KITTITAS COUNTY COMMUNITY DEVELOPMENT SERVICES

January 15, 2010

Subject: No. 5 Canyon PUD Application (RZ-09-00001)

# NO. 5 CANYON PLANNED UNIT DEVELOPMENT

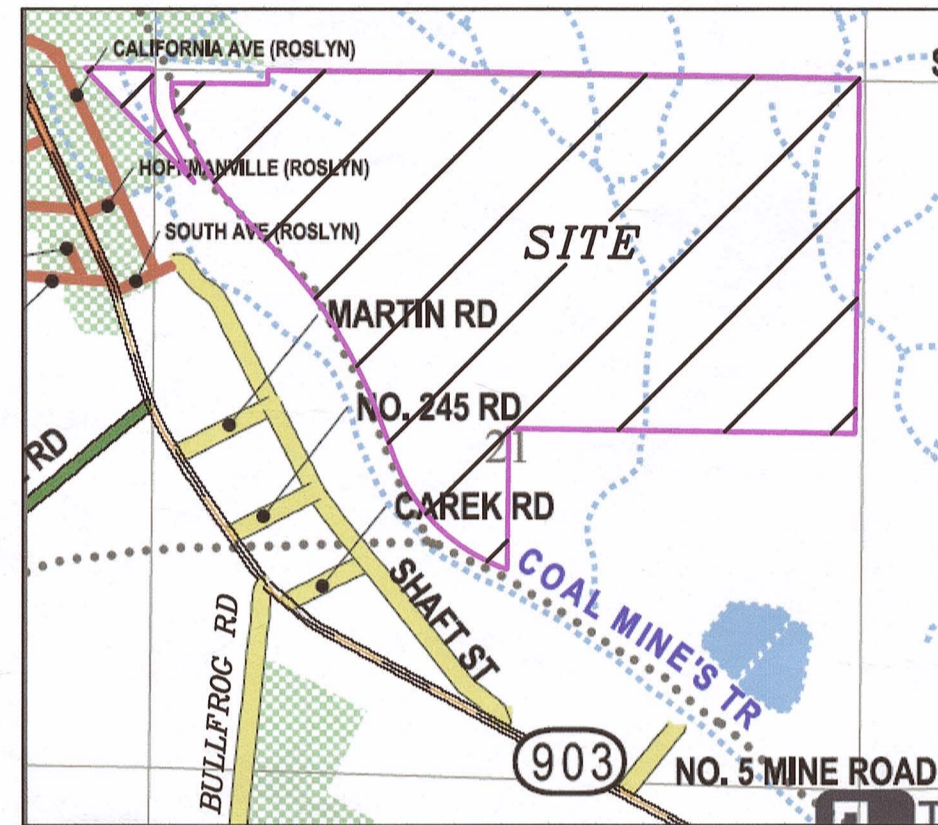
The proposed density of 7 dwelling units per acre is characterized as Urban, the current Comprehensive Plan Land Use designation is Rural. The 25 acre professional business park and 4.6 acres of new commercial development conflicts with GPO 8.50 which states; "*In the case of Planned Unit Developments (PUD's), only residential PUD should be permitted outside UGA's*". The project is located outside of a UGA.

In order for this project to proceed, an amendment to the Land Use designation from Rural to Urban must occur, and the language from GPO 8.50 would need to be changed to allow mixed use PUD's outside UGA's. The 2010 Comprehensive Plan Amendment applications are being accepted until June 30, 2010.
